Application No: AW/78/22/PL
Site Address: Southmead Canons Close Aldwick PO21 4EB
Description of works: Variation of condition 2-plans condition imposed under AW/259/21/HH to extend front of property approximately 2m further than approved.

Thank you for your internet representation made on 10th April 2022 which has been recorded as an objection with the comments as follows:

DRAWING REV 3 VERSION 01

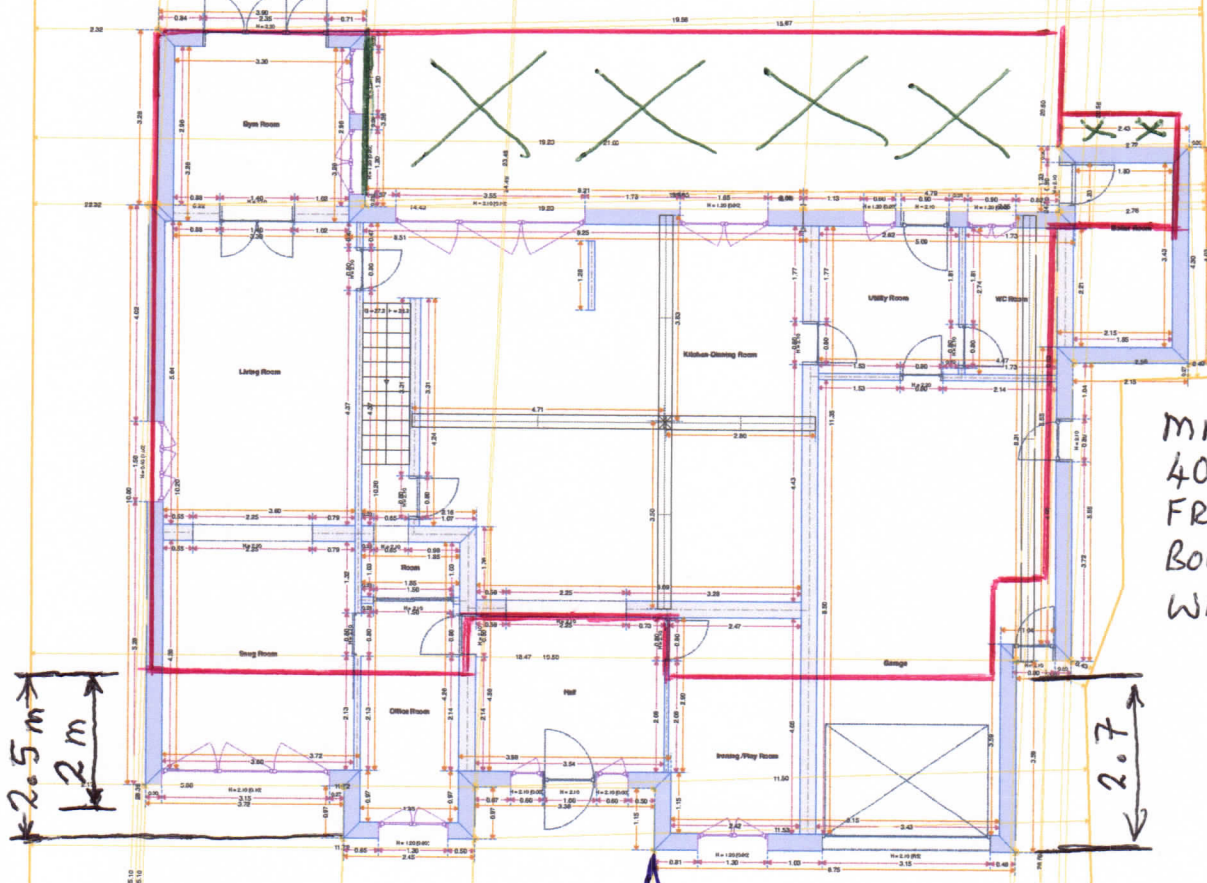
No overall dimension has been shown between the existing left side building line and the proposed projecting front face. I have assessed this as 4.7m.

The pending application should show the profile of the adjacent front corner of Bell House which is 1.14m in front of Southmead. Planning consent has already been permitted for a ground floor front extension of 2.2m. The current application proposes a further forward extension of 2.5m giving a total 4.7m projection in front of the existing building. This would be grossly excessive as it would be 3.56m forward of the adjoining Bell House and even further forward than no.2 Timperley House.

The proposal would have a flat roof which is alien and out of character to the rest of Canons Close properties.

In addition, there is now increased accommodation to the first floor over the garage and a dormer in the roof on the second floor. No details are shown in the application of this additional accommodation in the roof.
